Application for a non-material amendment following a grant of planning permission.
Town and Country Planning Act 1990

Conversion of outhouse (B1 Business / B8 Storage & distribution) to form Cafe, Office, toilets & include small extension (B1 Business / A3 Restaurant & Cafe)

Reference number: F/20/16/PL

6. Non-Material Amendment(s) Sought

Drawing: PLANS, ELEVATION EAST & WEST PROPOSED			
Drawn JD	Date NOVEMBER 2016	Scale 1:100 @ A3 1:50 @ A1	
Job No. J.1989	Drg. No. C.05	Rev. E	
Drawing status CONSENT

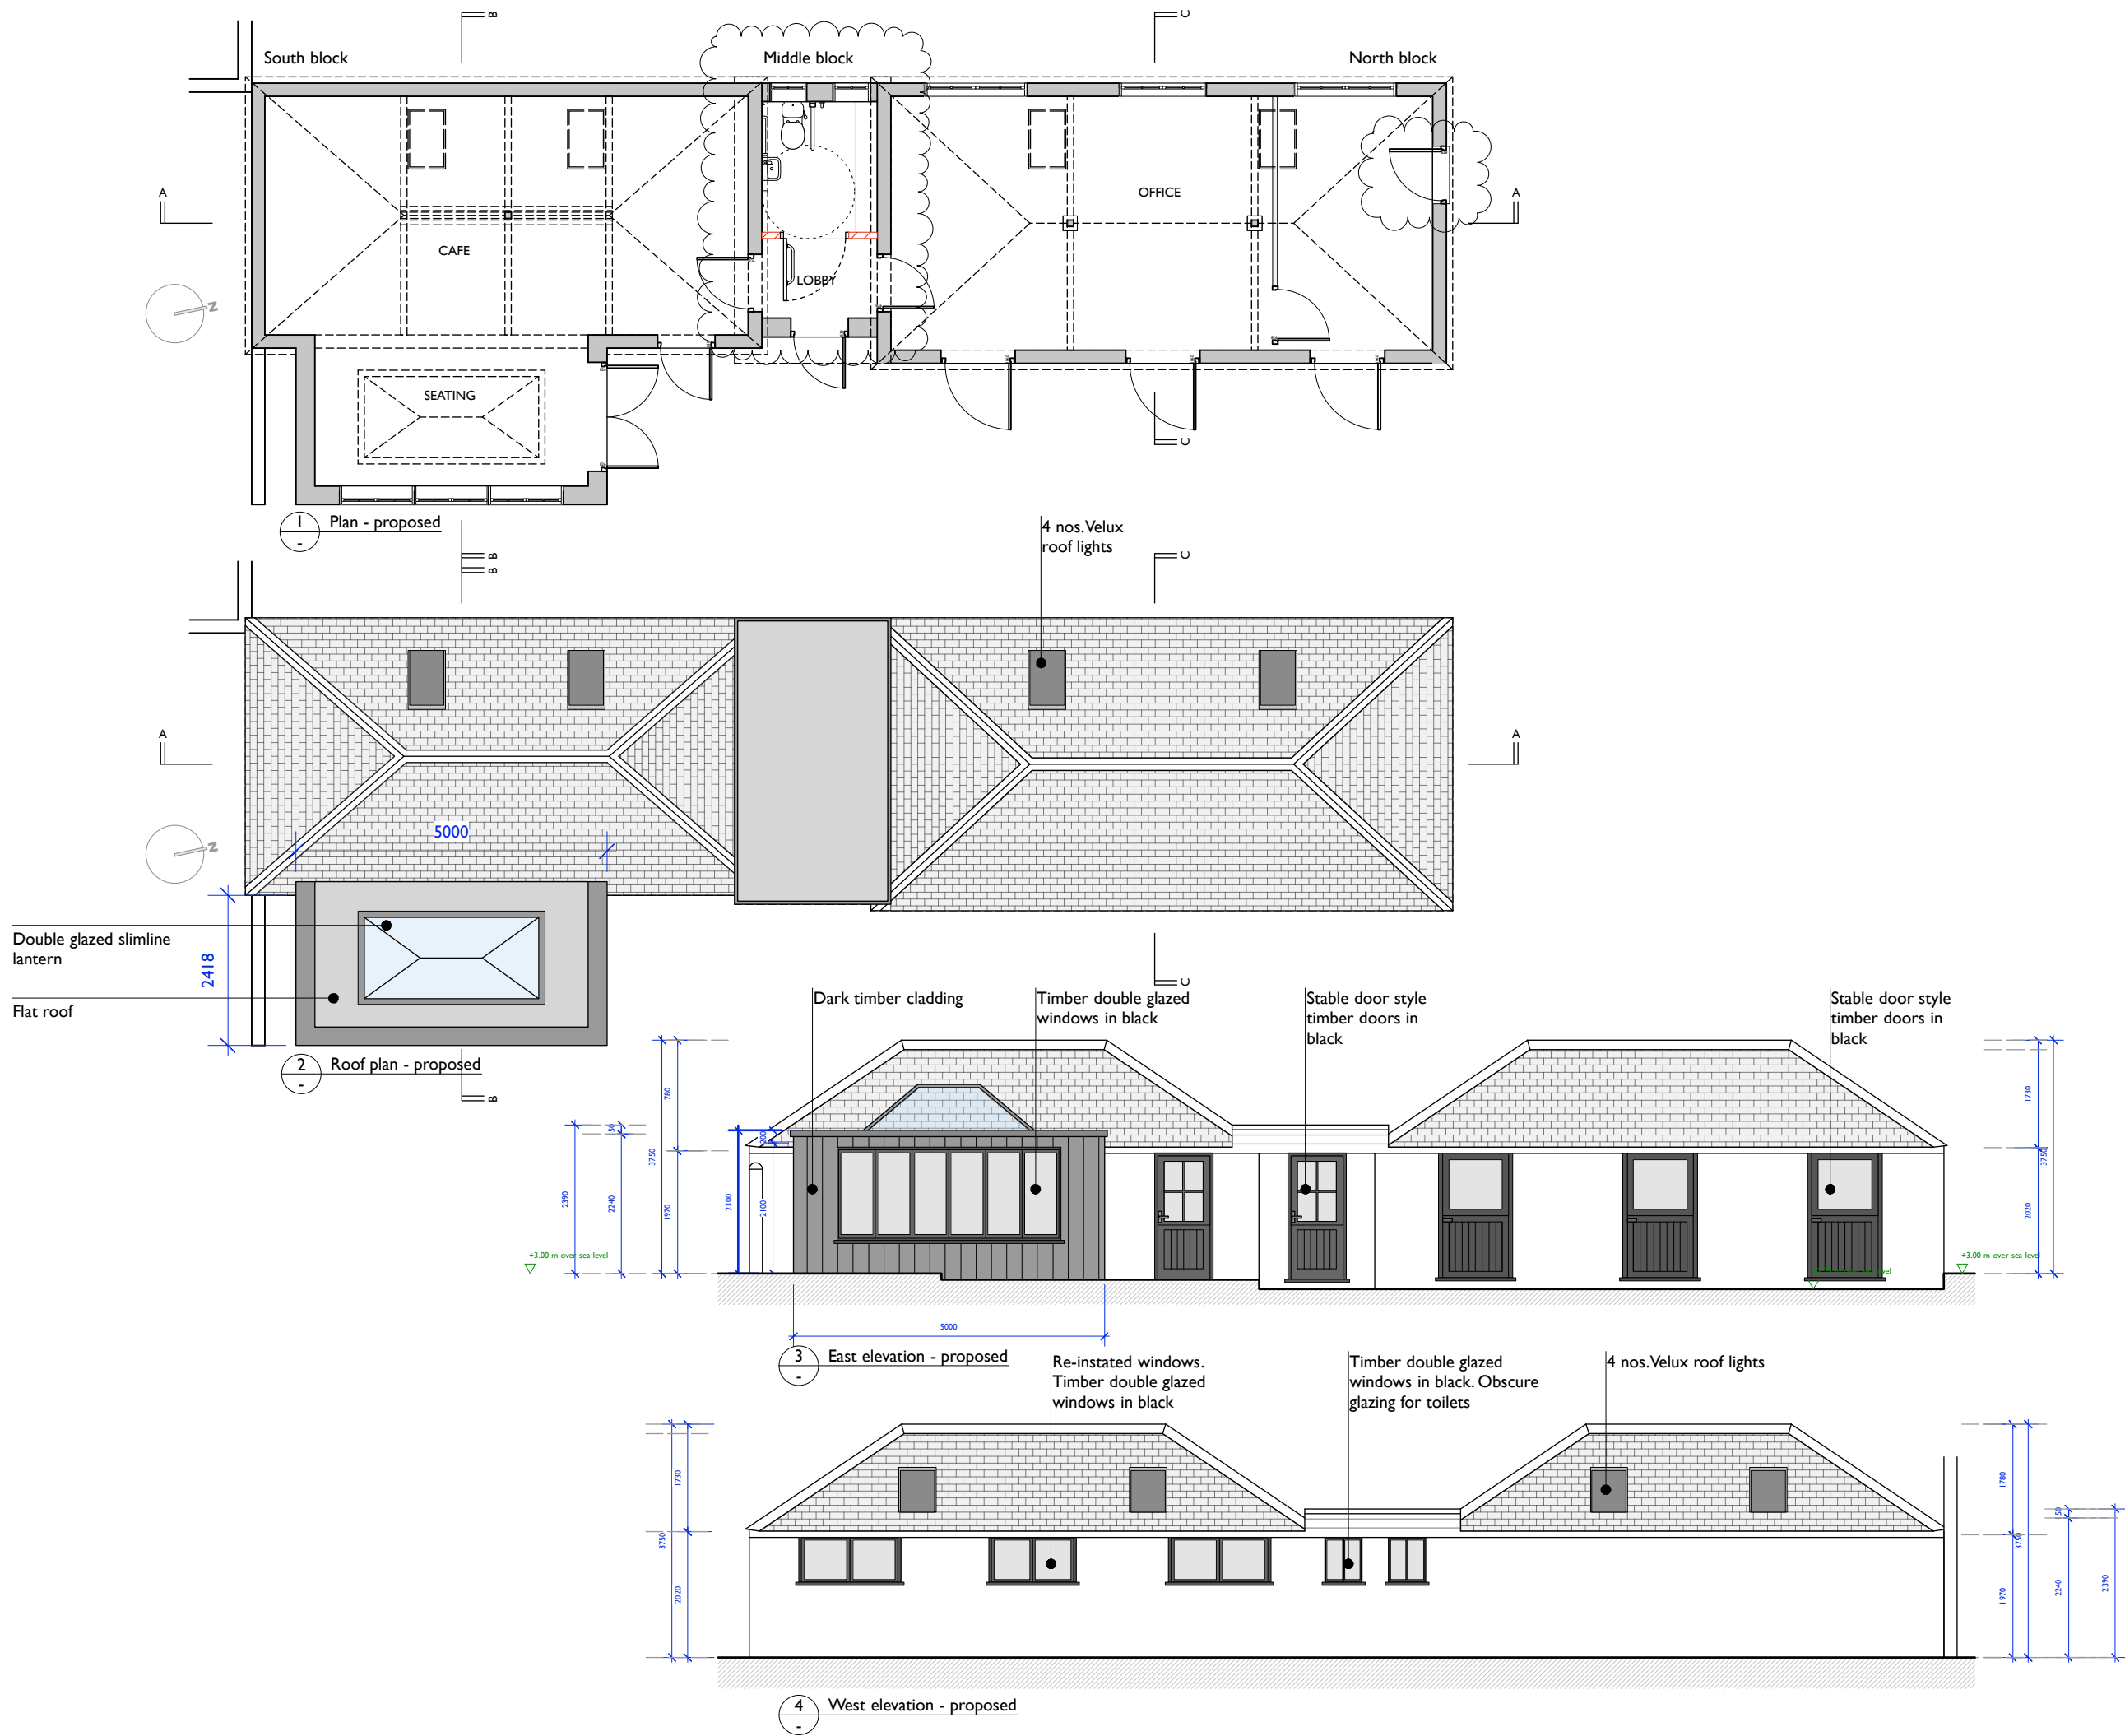
My client would like to revise the 2 w/c approved into 1 accessible w/c. My client would also like to add a single leaf door to the rear of the office on the north elevation.

The number of covers has reduced in the cafe, so only 1 toilet is necessary. The additional door in the office offers better circulation and exit from the property.
